**Subject:** Meeting Notes for NEPA/404 Merger Team Concurrence Point 4B  
TIP Project B-4929 (Topsail Island Bridge Replacement)

A NEPA/404 Merger Team meeting for the subject project was held on March 12, 2015 in NCDOT's Structure Design Conference Room. The purpose of this meeting was to reach agreement on Concurrence Point (CP) 4B (30% Hydraulic Review).

**Presentation:** Mr. Bollinger presented a PDF of the 30% redline drainage plans, and discussion included the following:

INFILTRATION BASIN NO. 2 DETAIL

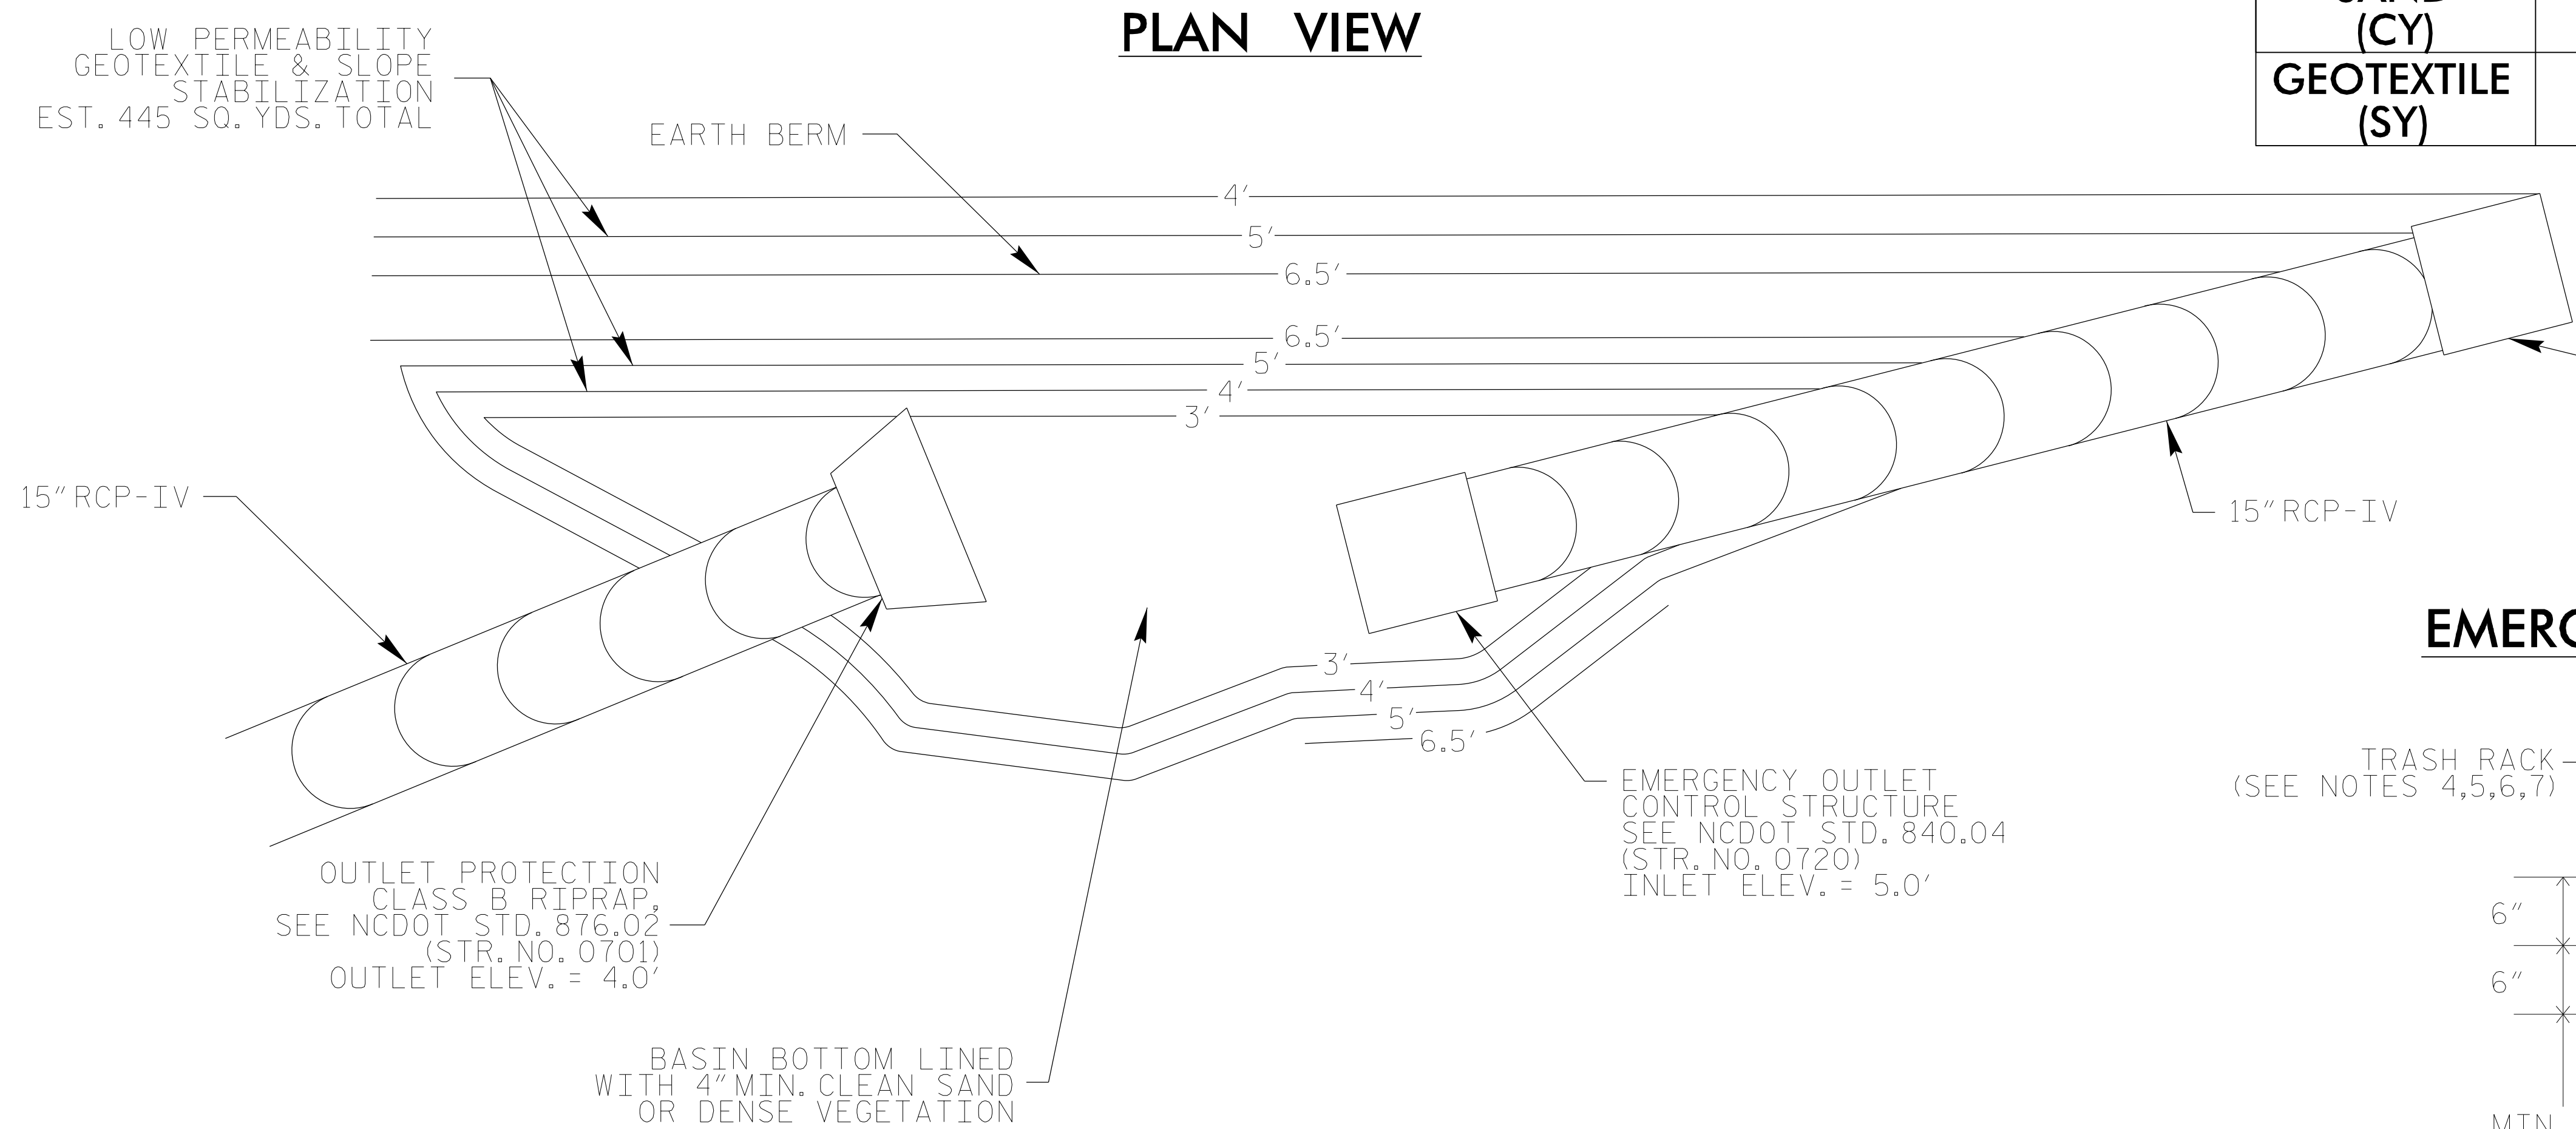
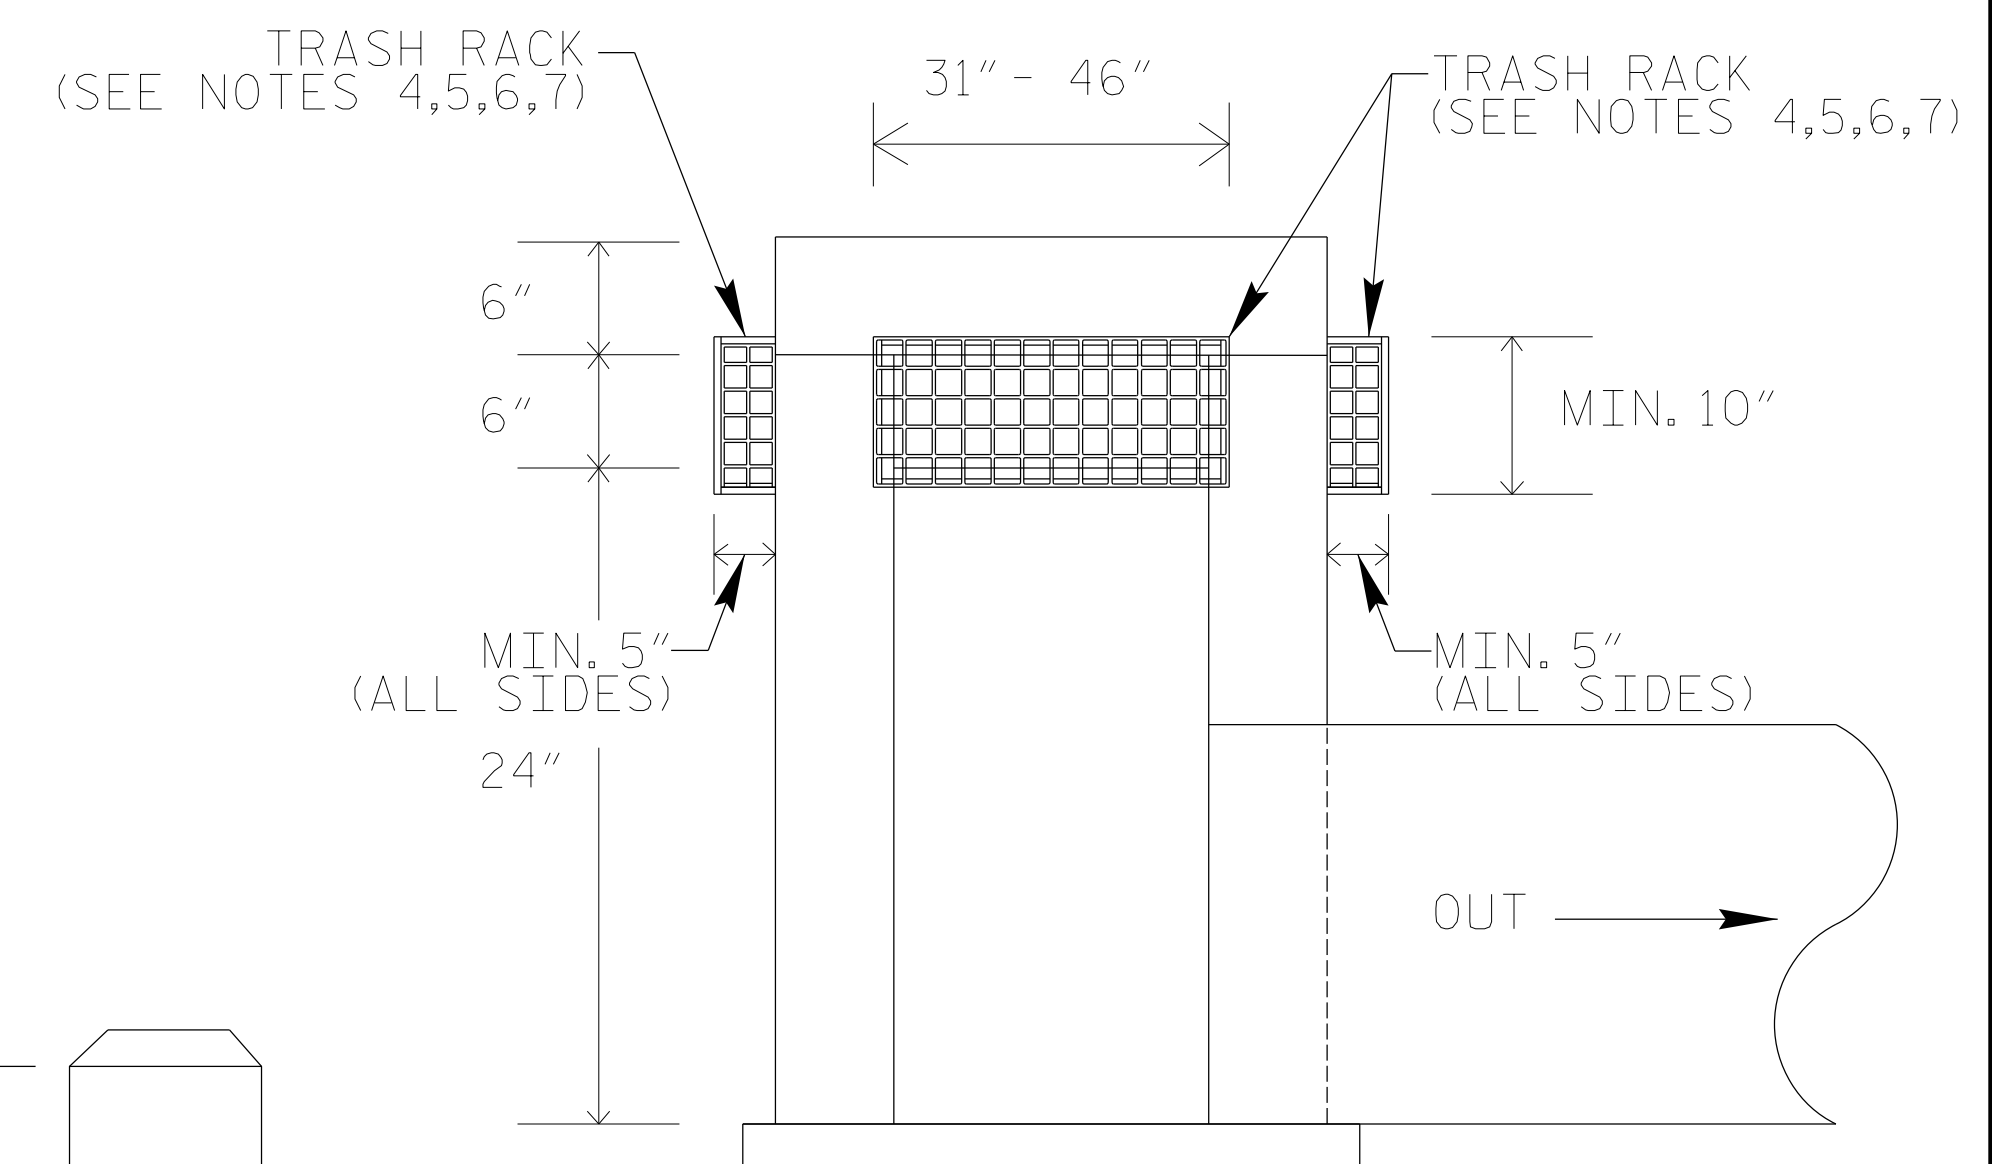
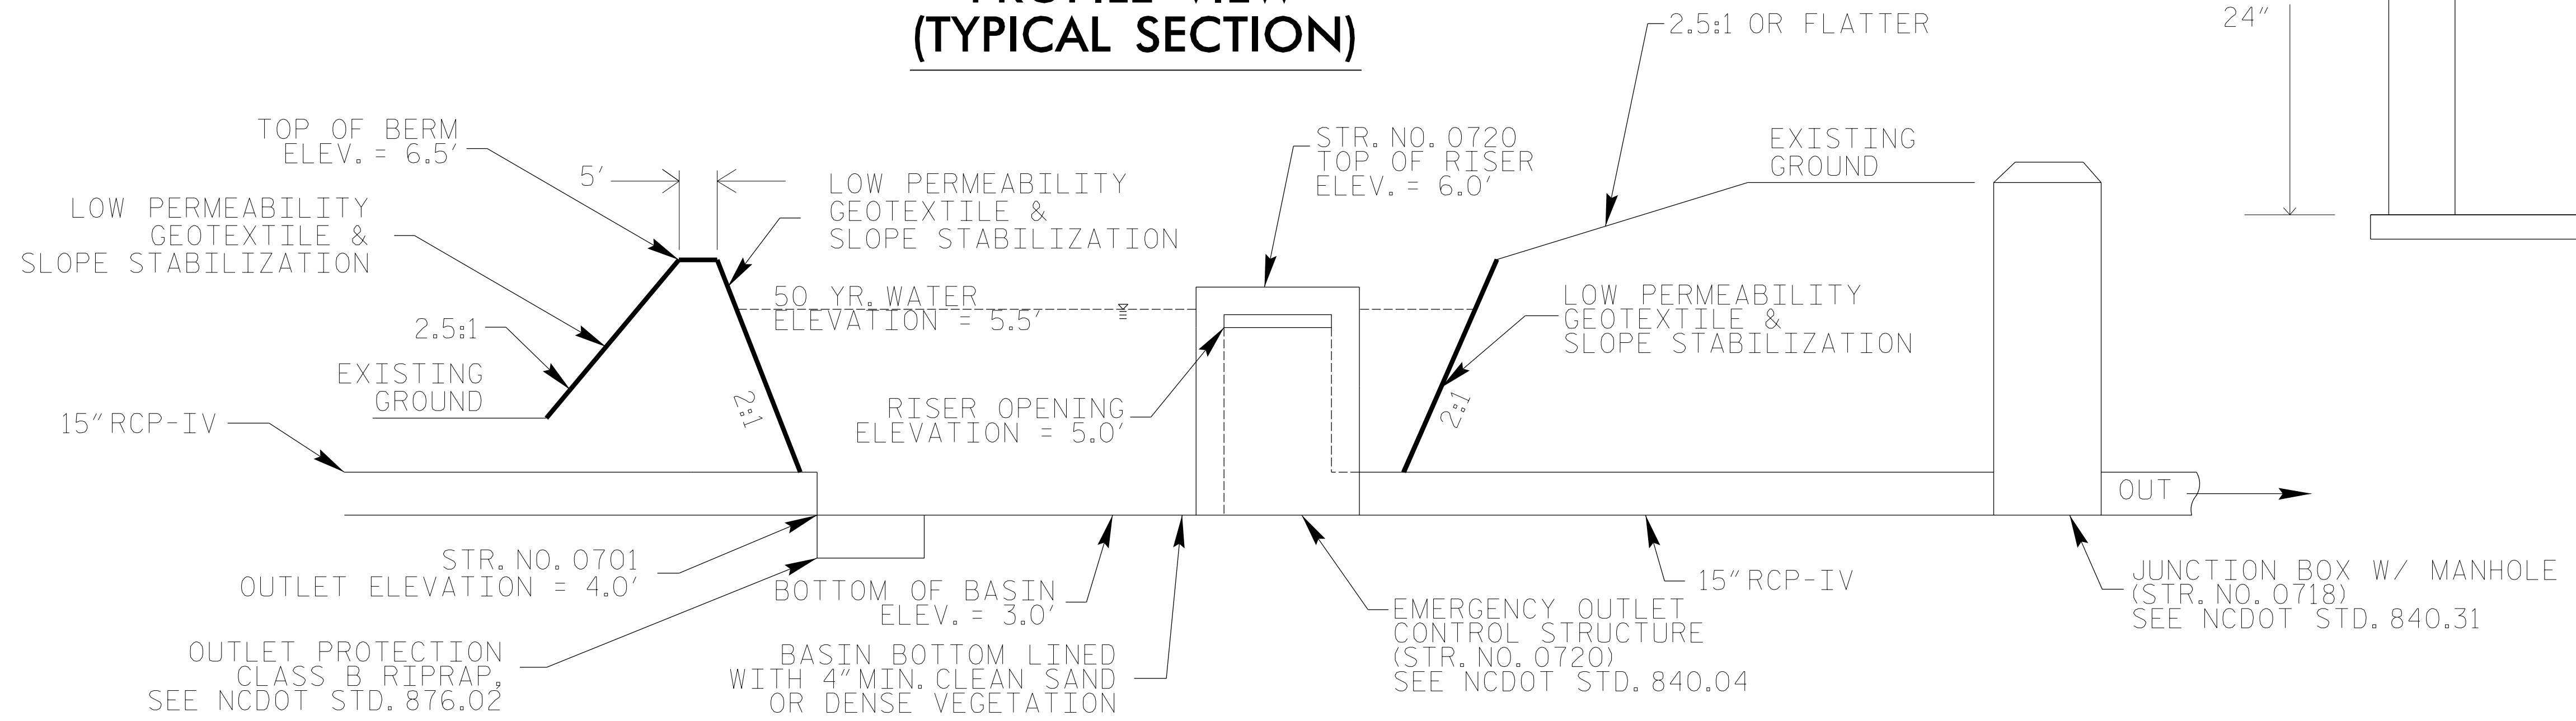
**MT Comment:** *Drainage basins should be located outside of wetlands and CAMA buffers (30 feet of the shoreline).*

**MT Comment:** *Mr. Herndon requested that NCDOT exhaust every option for treating all stormwater runoff from the bridge before proposing deck drains. MT attendees generally disapproved using deck drains over open water, particularly over Submerged Aquatic Vegetation (SAV) habitat.*

**PT Response:** Noted. Basins shown on the 30% hydraulic plans are subject to change and will likely be resized/relocated to minimize impacts. SAV surveys are scheduled for the summer prior to construction, and NCDOT will further refine the hydraulic plans in upcoming months.
